The Examining Authority's second written questions and requests for information (ExQ2)**3. Air Quality and Human Health**

Figure 4.1 – Proposed amendments to the visibility splay on Old Lane/Elm Lane corner (extract of dwg: HE551522-ATK-HGN-XX-SK-CH-000093_C01)

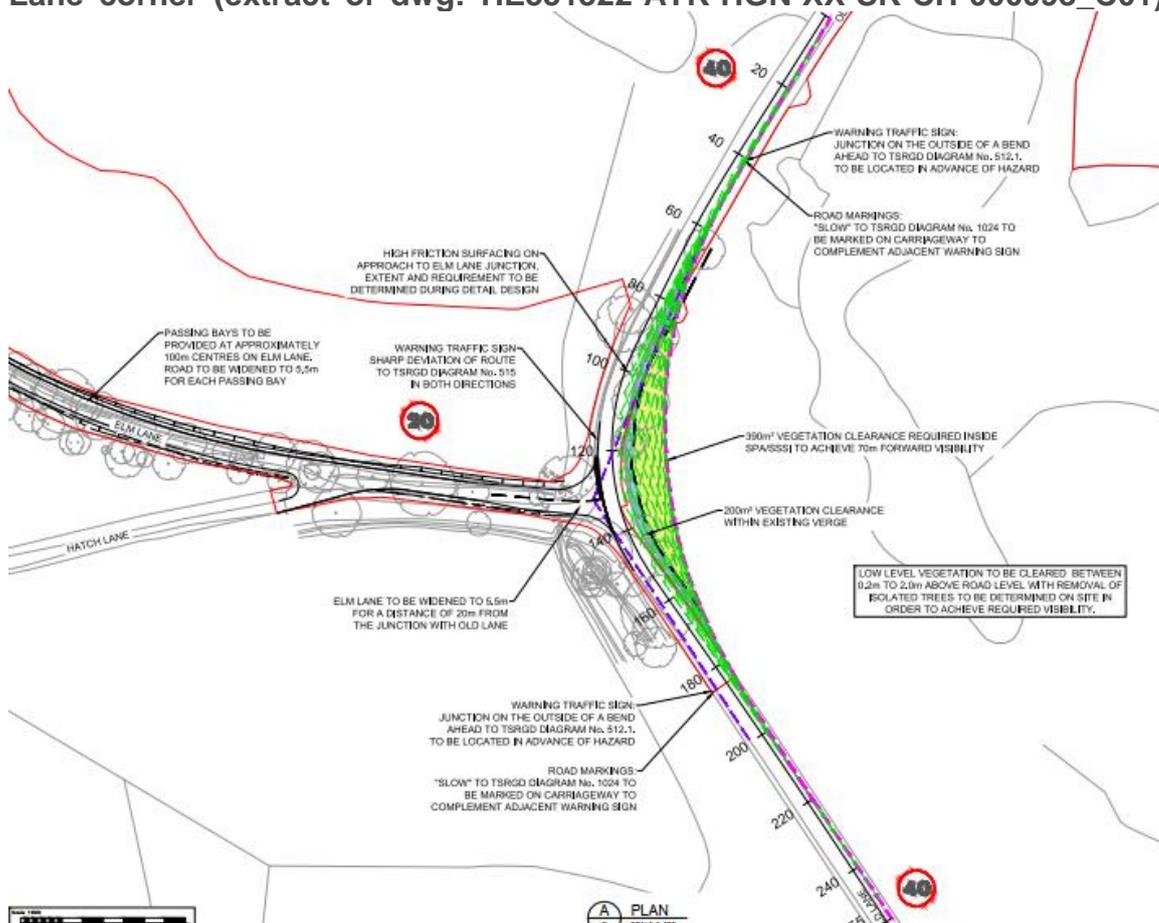
2.13.30 The visibility splays exiting Elm Lane onto Old Land shown on drawing HE551522-ATK-HGN-XX-SK-CH-000036 within Appendix A of REP4-006 require vegetation clearance as shown on this plan. In our early consultations with HE we discussed with them the need for traffic slowing measures between the A3 and this exit in order to:

a) ensure this junction is safe

b) to slow down the traffic travelling along Old Lane from the A3/M25. A vast number of cars currently motor at very high speeds along this stretch of Old Lane and there have been many accidents on this bend, at least one of which was fatal. We suggest that HE or SCC may have some statistics on the accident rate at this bend.

c) to avoid habitat loss (i.e. clearance of trees) in the SPA. If the safety of this junction is considered to be satisfied by vegetation clearance only, then this will have to be an ongoing maintenance requirement for guaranteed future safety of this junction.

We suggest that there is further discourse with Elm Corner Residents and Surrey CC about the detailed design of this junction and that measures are taken to ensure that traffic is slowed down in Old Lane (SCC should be able to provide statistics showing that vehicles regularly exceed the 40 mph speed limit. Ockham and Hatchford Residents Association also have some evidence of this) and habitat loss is kept to the minimum.
